Phone: 0300 123 6780  
Email: lhscustomerservice@lancashire.gov.uk  
Your ref: 3/2015/0453  
Our ref: LHS/CS/3/2015/0453  
Date: 1<sup>st</sup> July 2015

| <b>Proposal:</b> | Conversion of Brook Wood Barn into a single residential property |
| <b>Location:</b> | Cherry Tree Farm Chipping Road Chaigley Clitheroe BB7 3LX        |

SITE PLAN

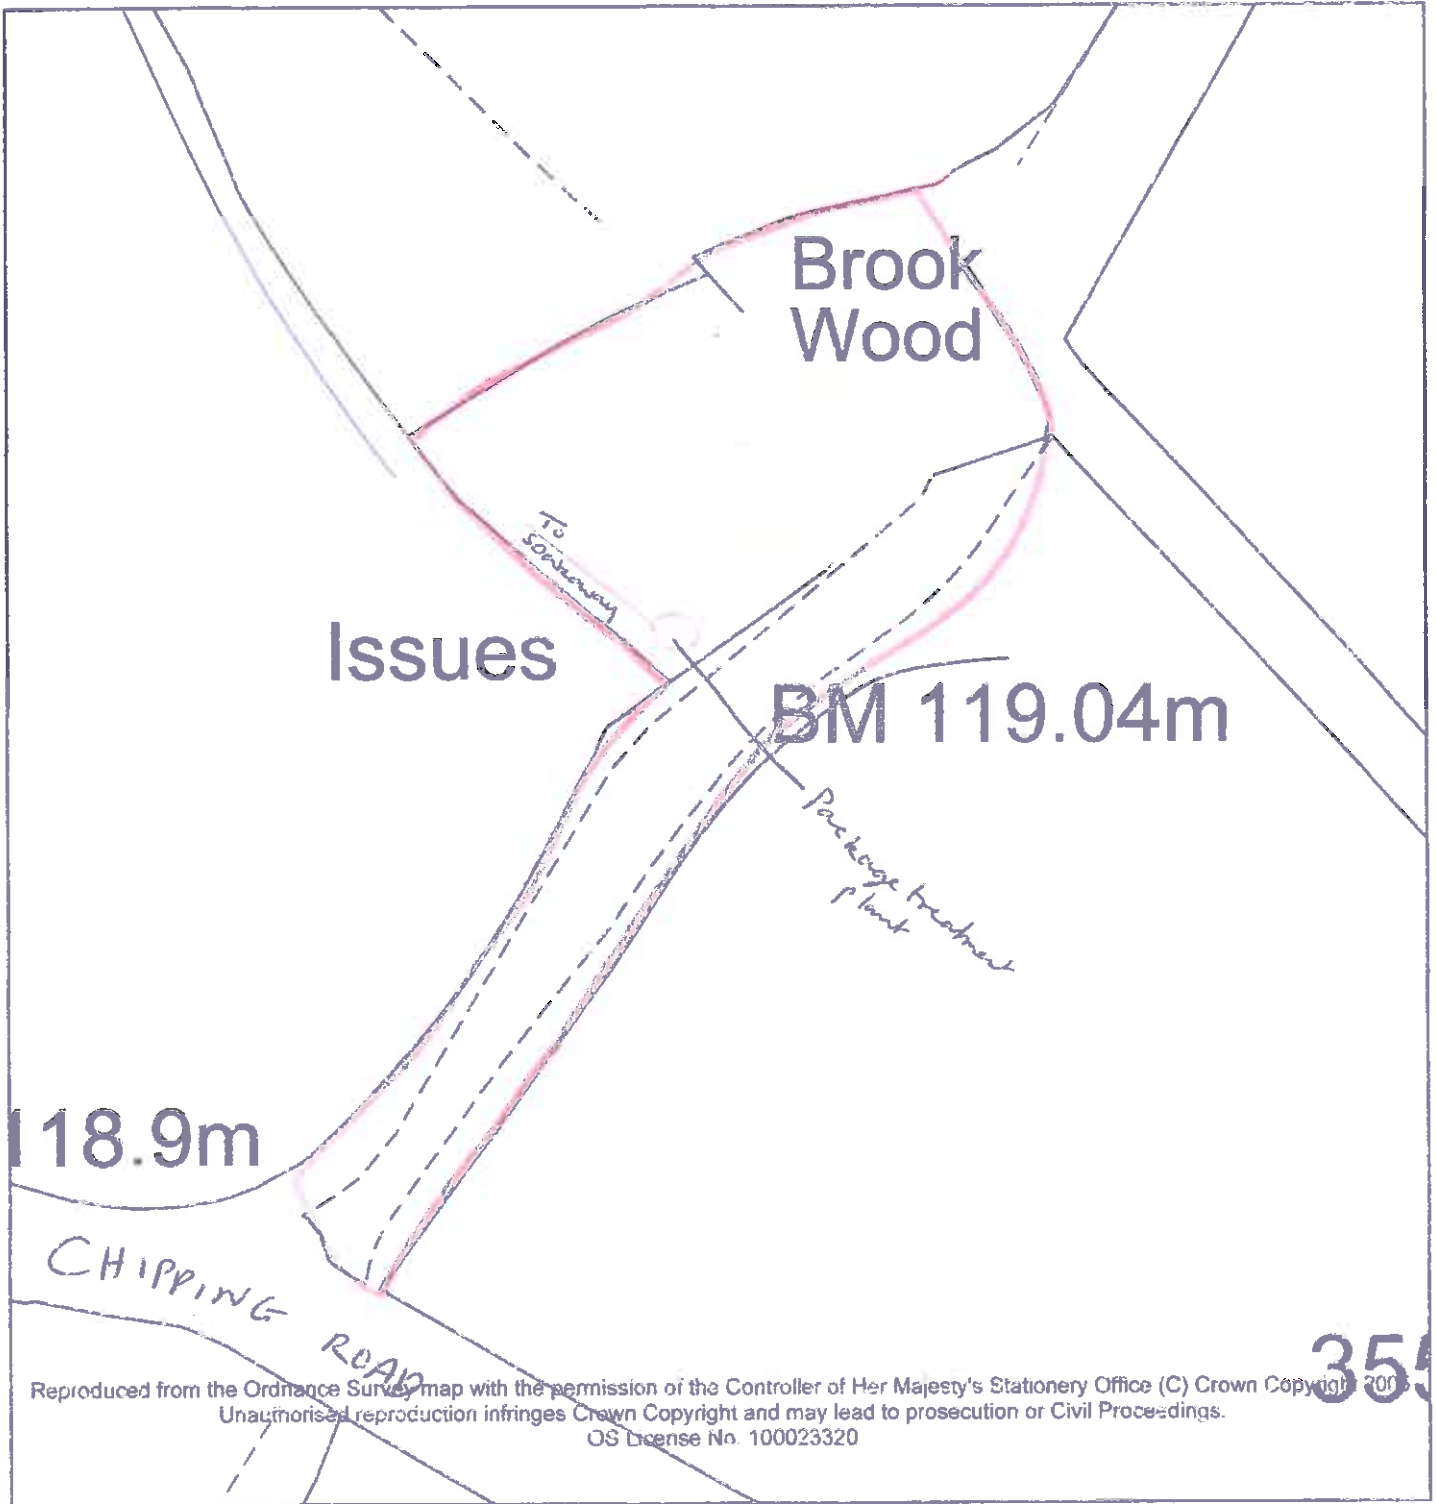
From our mapping system "Mapzone", the proposed development will have direct access along definitive footpath 3-3-FP 35. I have forwarded details of this planning application to Lancashire County Councils Public Rights of Way Section and asked them to contact you directly regarding any comments they may like to make.

Based on the Joint Lancashire Structure Plan the Highway Development Control Section is of the opinion that the applicant should provide three off road parking spaces for a 4 bedroom property. The applicant has not shown actual details for the parking but the Highway Development Control Section is of the opinion that this can be provided on site. The applicant should provide details of the required parking provision and ensure they do not obstruct definitive footpath 3-3-FP 35.

1. A car park and manoeuvring scheme to be approved by the Local Planning Authority and the car parking spaces and manoeuvring areas marked out in accordance with the approved plan, before the use of the premises hereby permitted becomes operative and permanently maintained thereafter. Reason: To allow for the effective use of the parking areas.
